Phone: (01772) 533855
Fax:
Email: david.allen@lancashire.gov.uk
Your ref: CONEH/3/2014/0764
Our ref: 03/14/0764/SHP/DRA
Date: 18 June 2015

**Application 03/2014/0764 - Development of 363 homes including affordable housing and housing for the elderly, relocation of Longridge cricket club to provide a new cricket ground, pavilion, car park and associated facilities, new primary school, vehicular and pedestrian access landscaping and public open space, with all matters reserved apart from access.
Land at Chipping Lane, Longridge.
Applicant Barratt Homes**

I refer to the above application, the Transport Assessment (TA) updated April 2015 produced by Vectos and the other documents in support of the application by Barratt Homes for 363 dwellings and LCC previous comments.

DRAWING TITLE:
**Proposed Connection
 to Bus Stops**

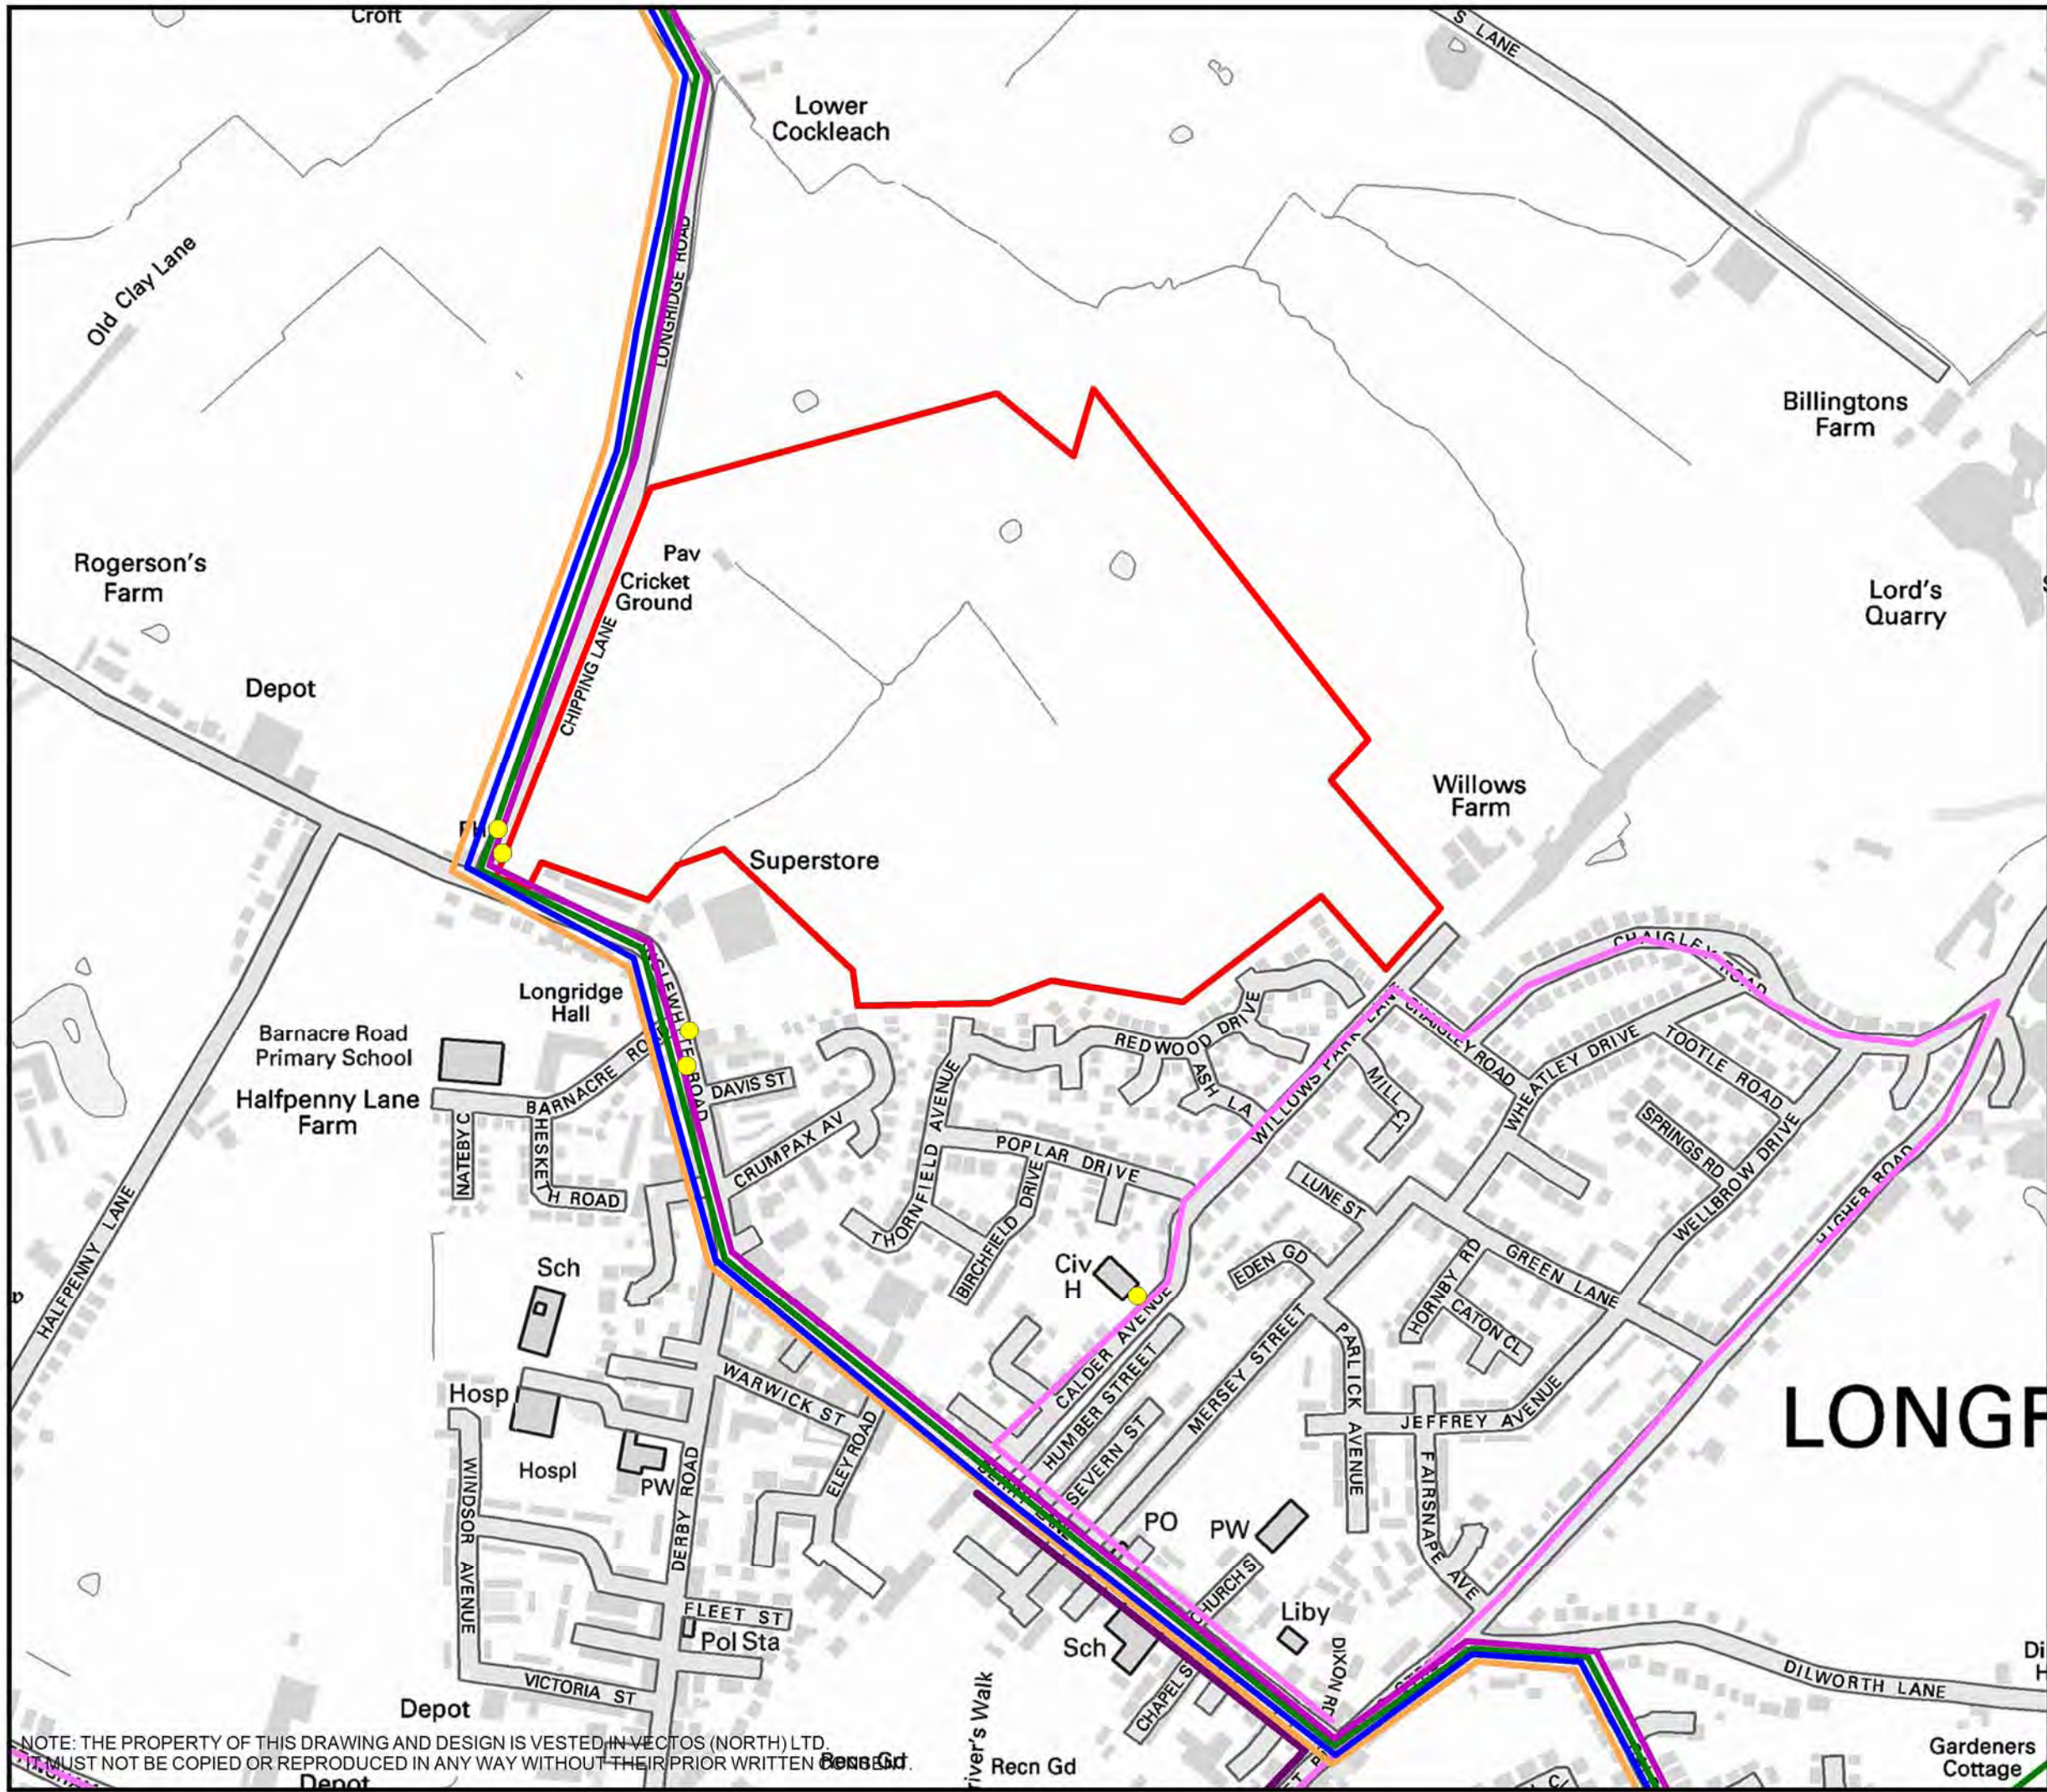
The TA Plan 6 now indicates that a pedestrian connection will be provided from the site to the existing bus stops along Chipping Lane. New footways will be provided along the site frontage, in addition a section of verge on the west side of Chipping Lane will be replaced with footway and the existing bus stops upgraded. These bus stops upgrade should be to mobility/quality bus standards. Plan 6 also indicates potential pedestrian routes to Thornfield Avenue, Redwood Drive and Willows Park Lane to link south to the town, satisfying the requirements of NPPF for integration with the existing built environment.

c) Bus stop improvements/upgrade to quality bus standard and footway connection including footway alignment splayed to allow sufficient forward visibility to junction of Chipping Lane and Inglewhite Road, subject to detailed design, as shown on Plan 7, Drawing No. VN30277-202.
